CITY OF ALBUQUERQUE

**Re: Sandia View Assisted living,
4631 Mi Cordelia Dr. NW 87120
Request for Certificate of Occupancy
Transportation Development Final Inspection
Engineer's/Architect's Stamp dated 2-22-17 (F11D015)
Certification dated 10-22-18**

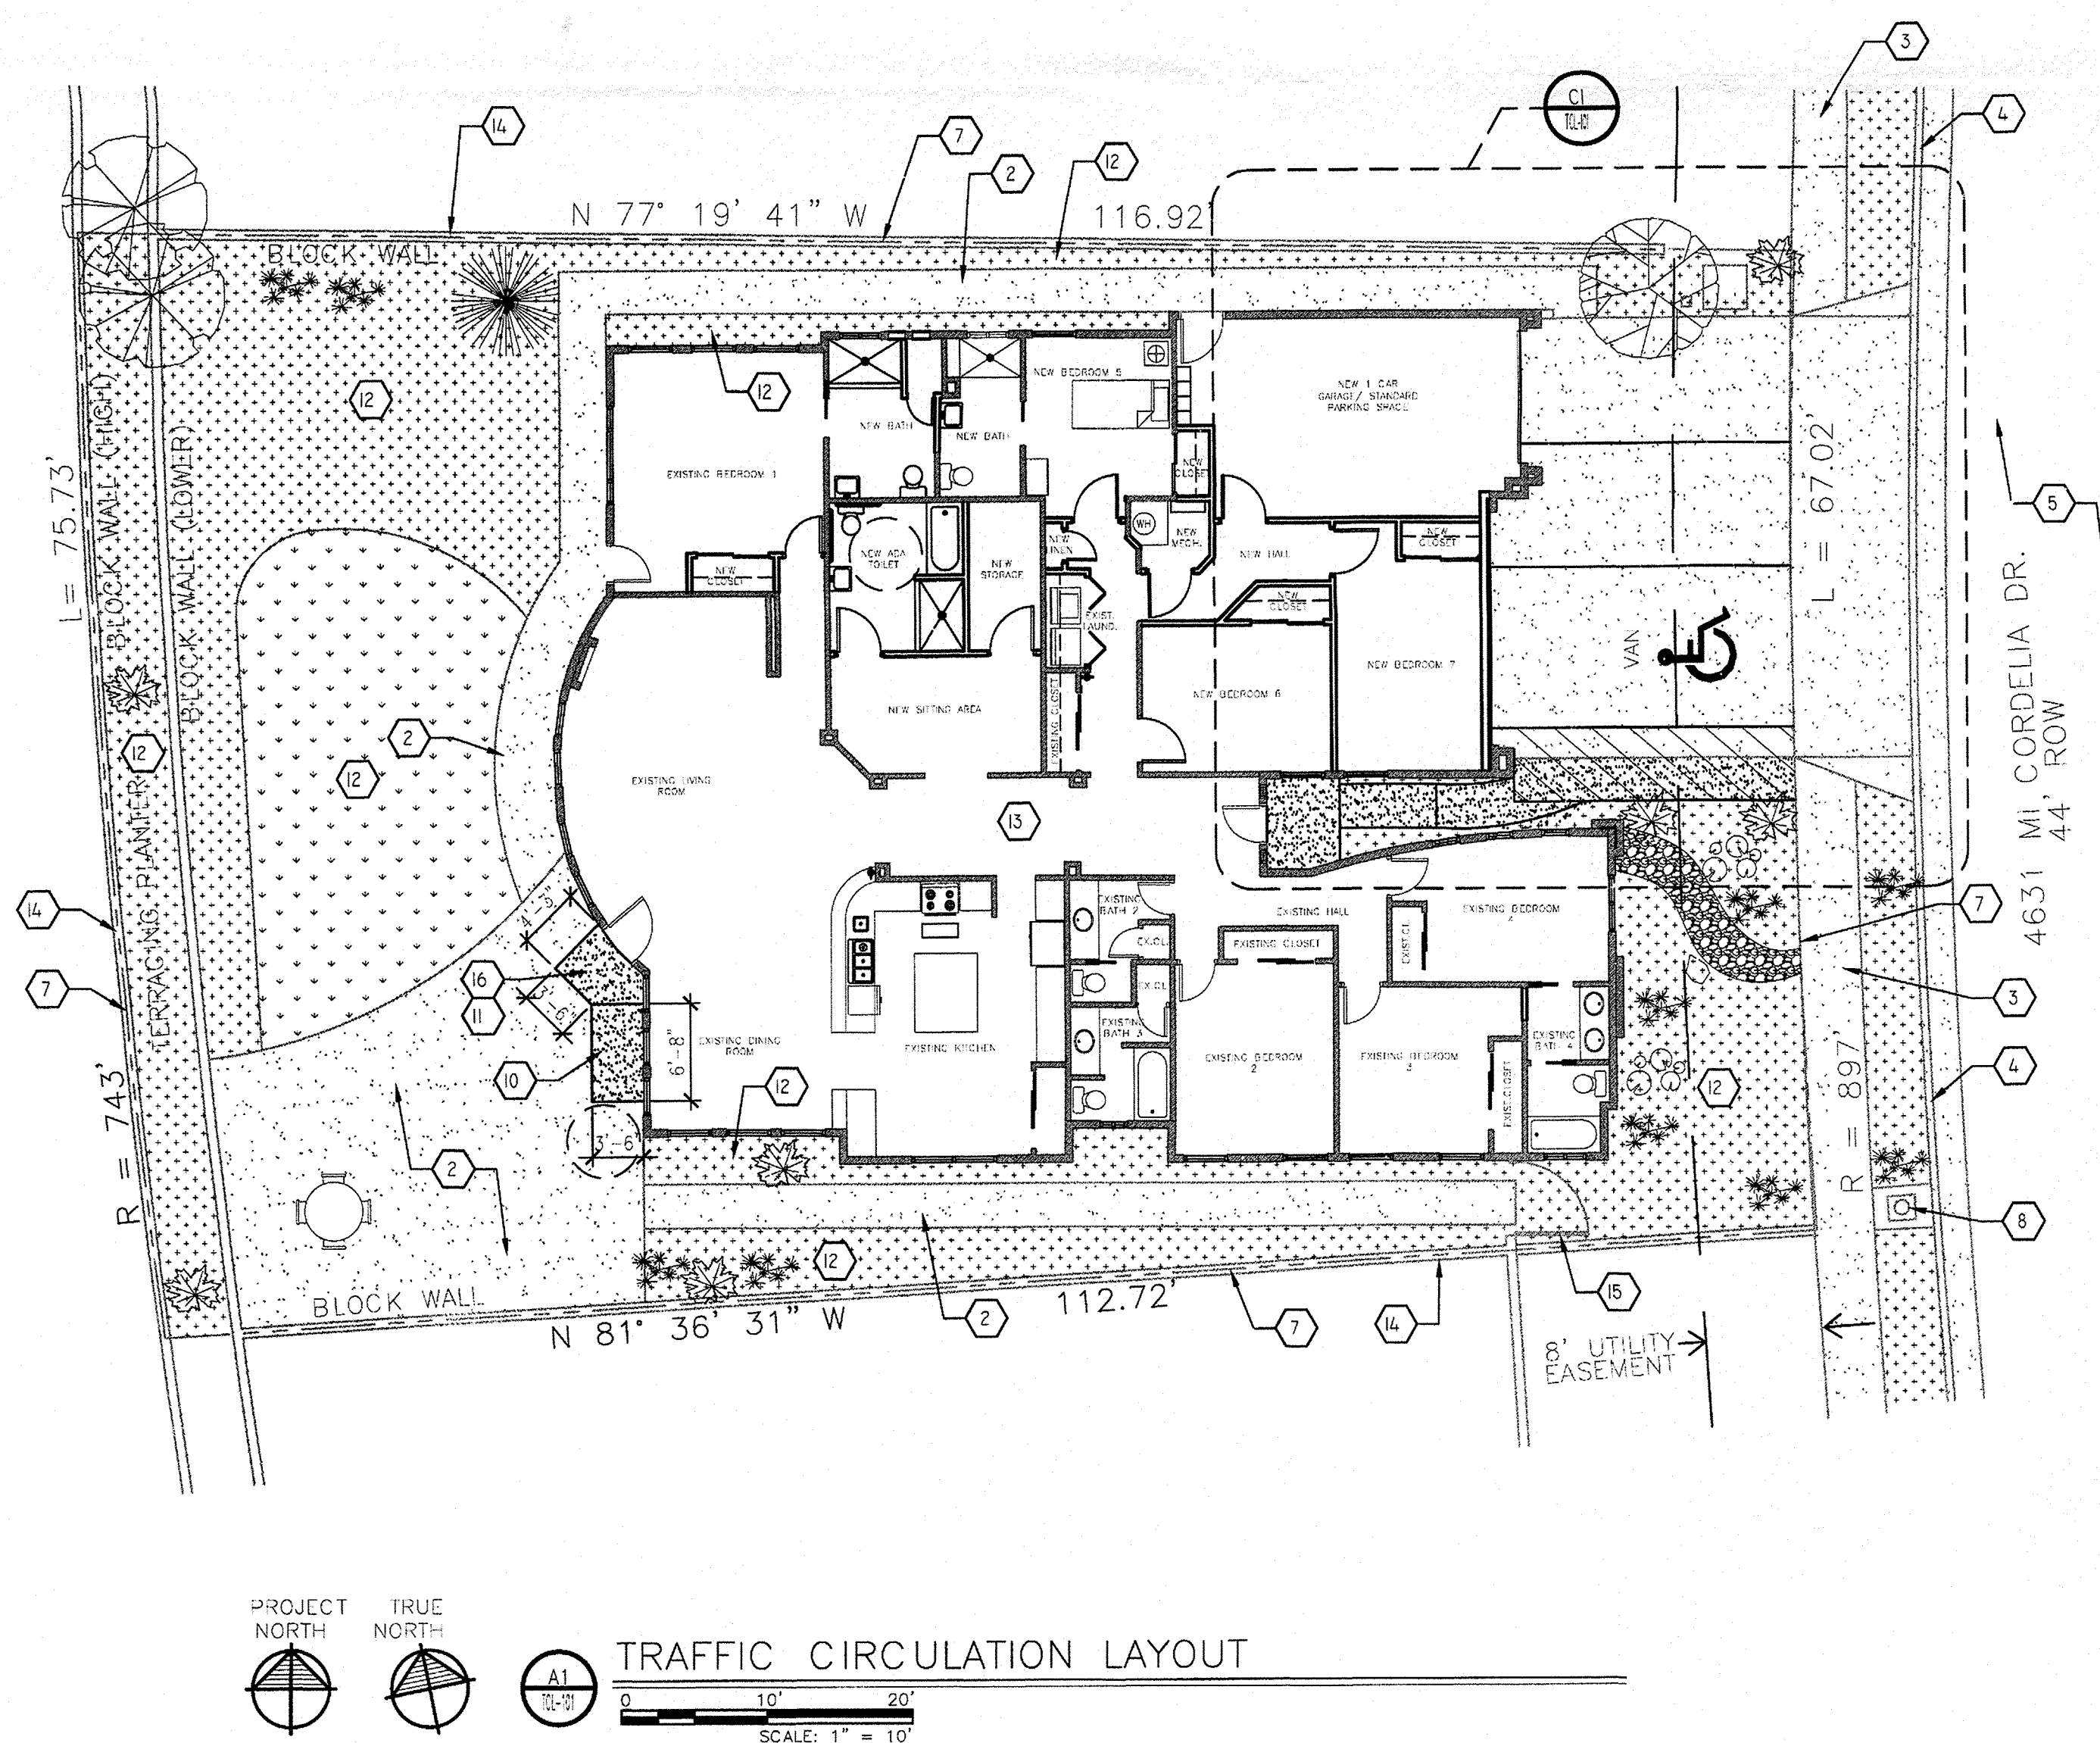
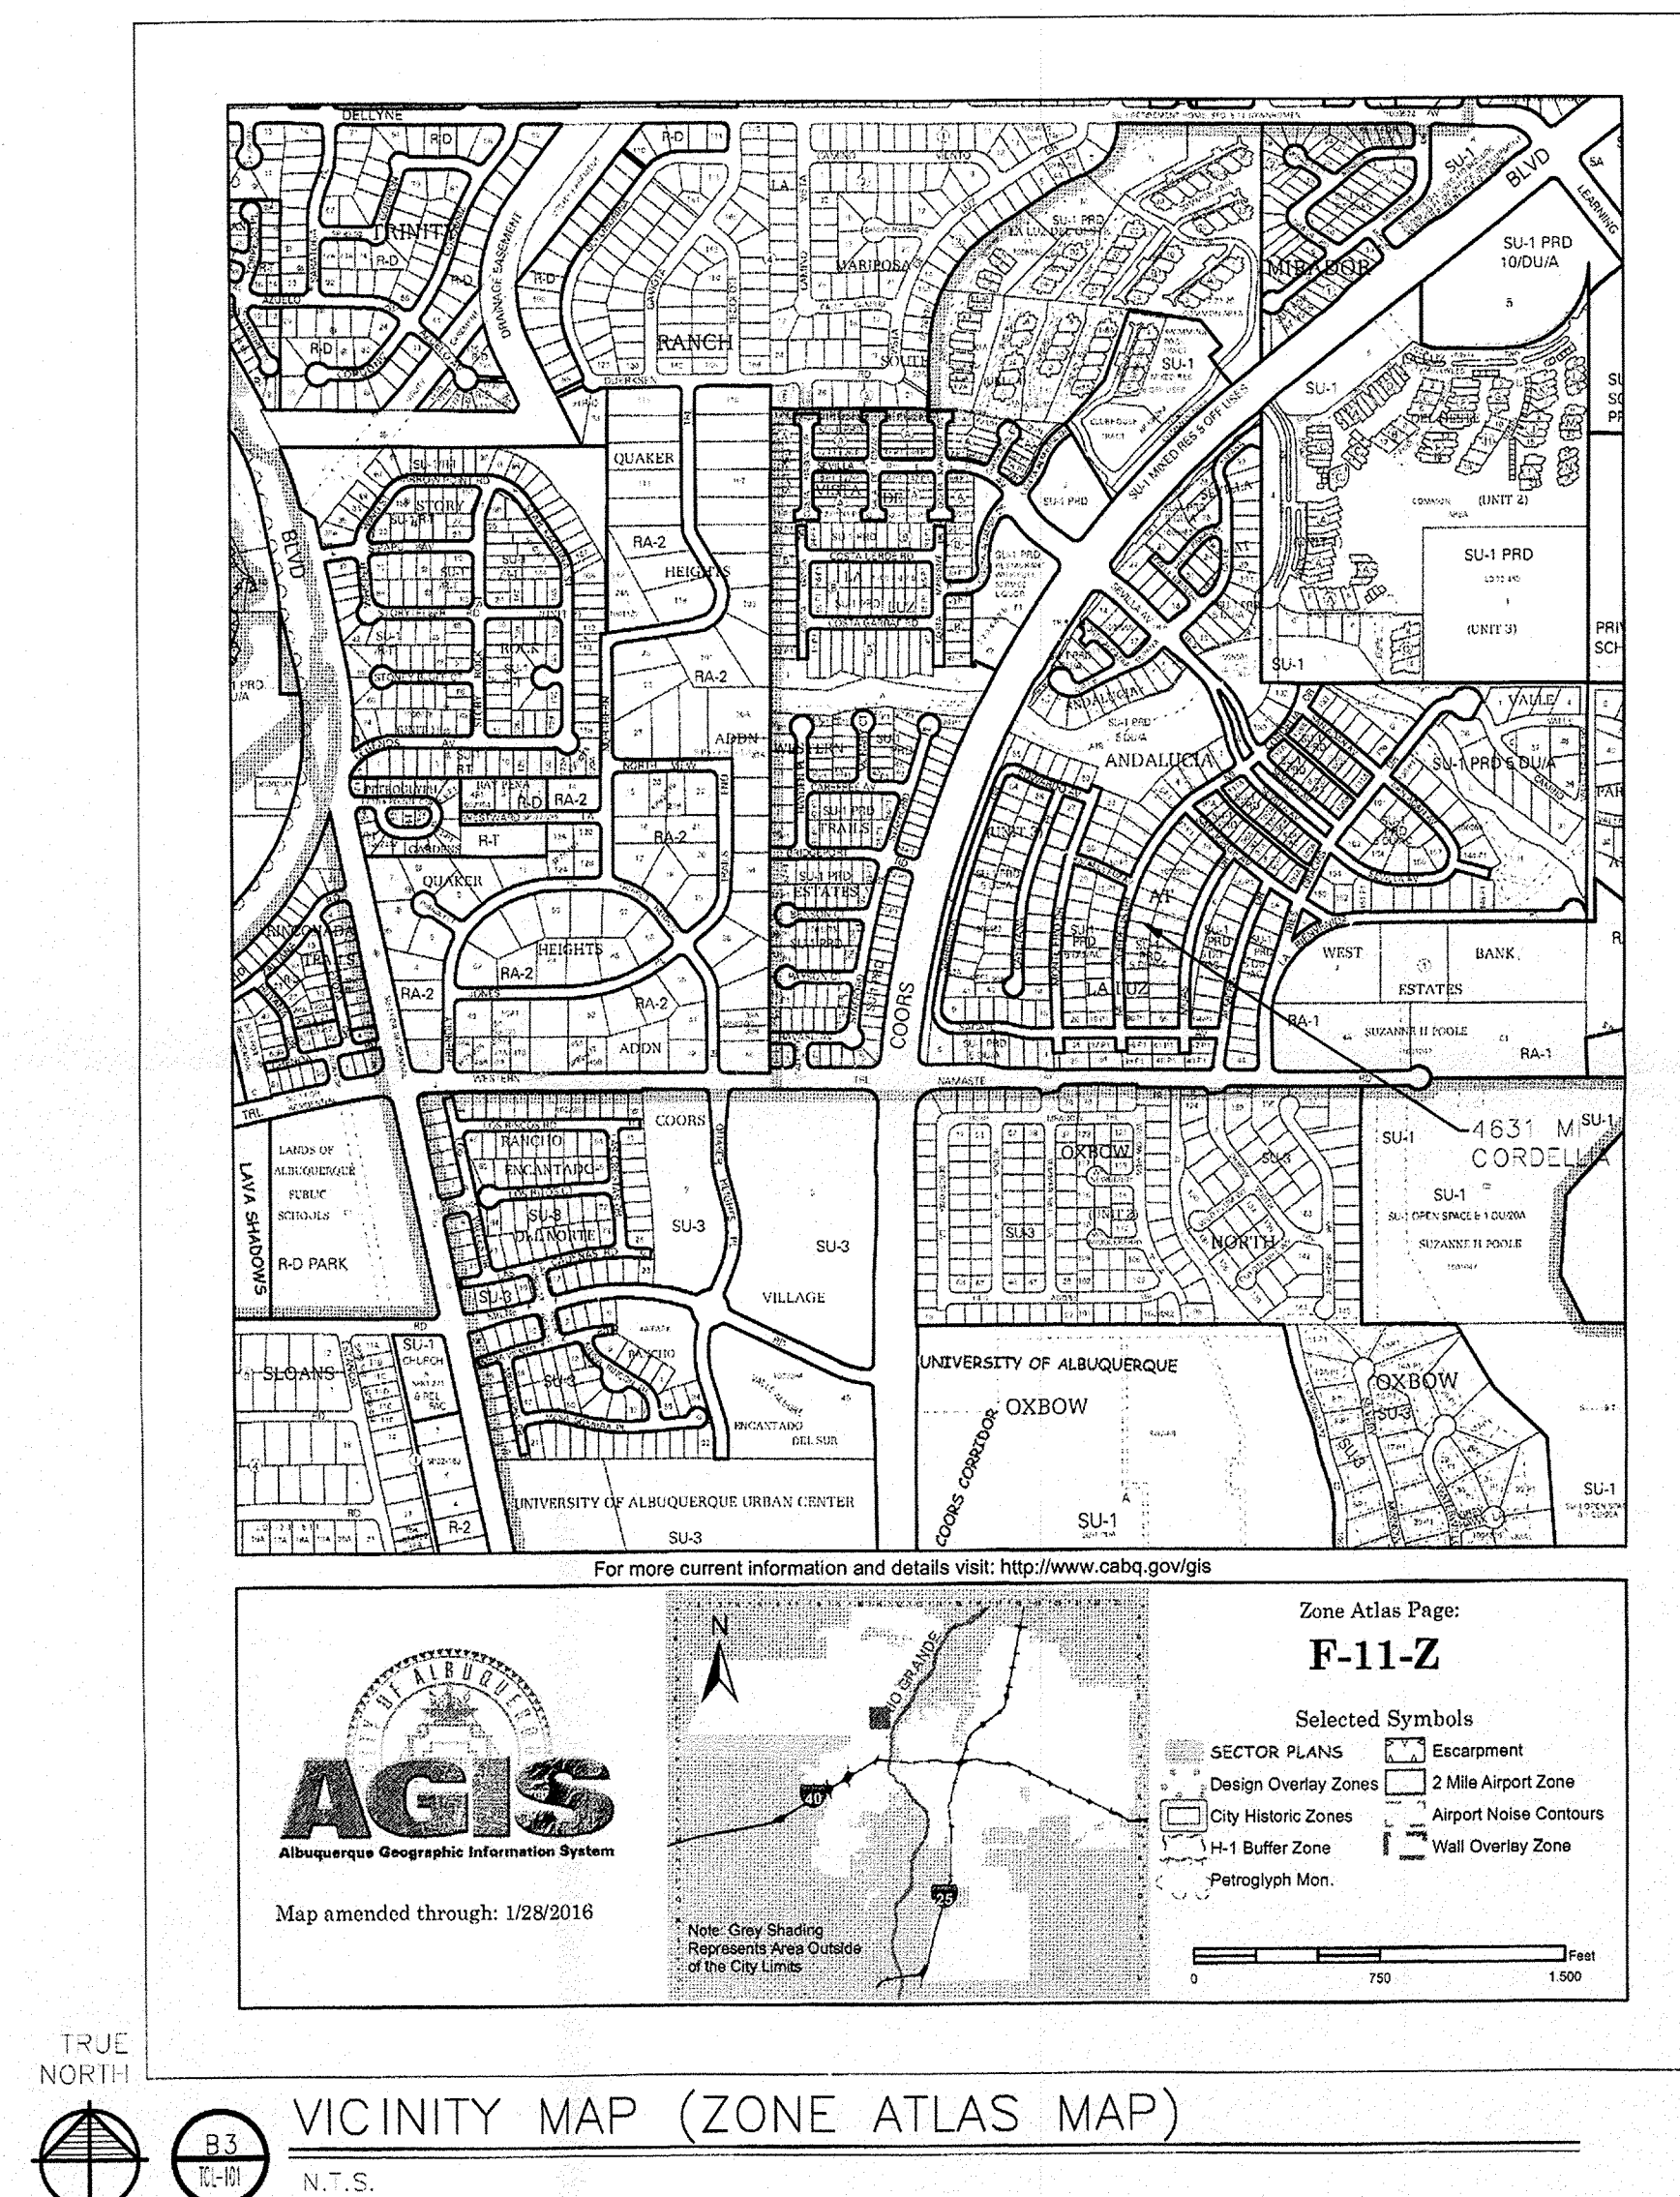
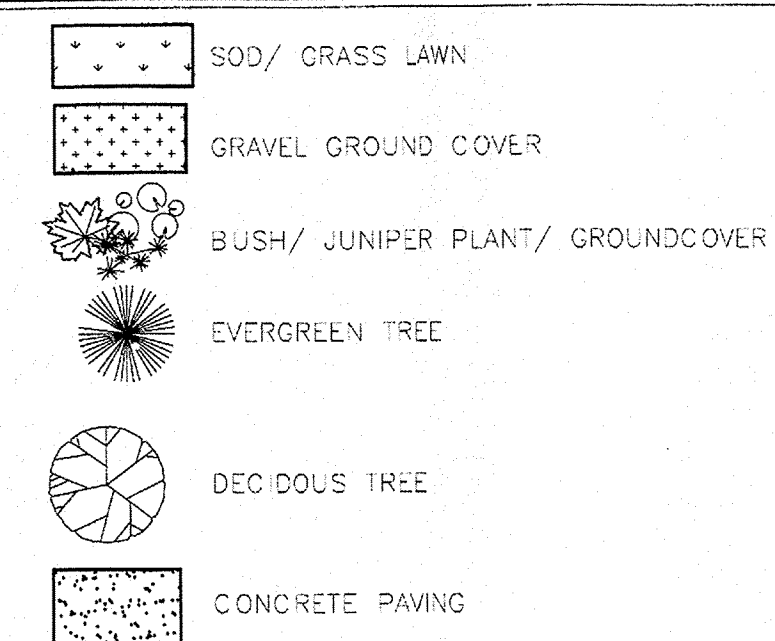
- Please correct ADA parking sign.
- Please stripe access aisle and add NO PARKING.
- Please stripe ADA Parking Stall per approved TCL plan.
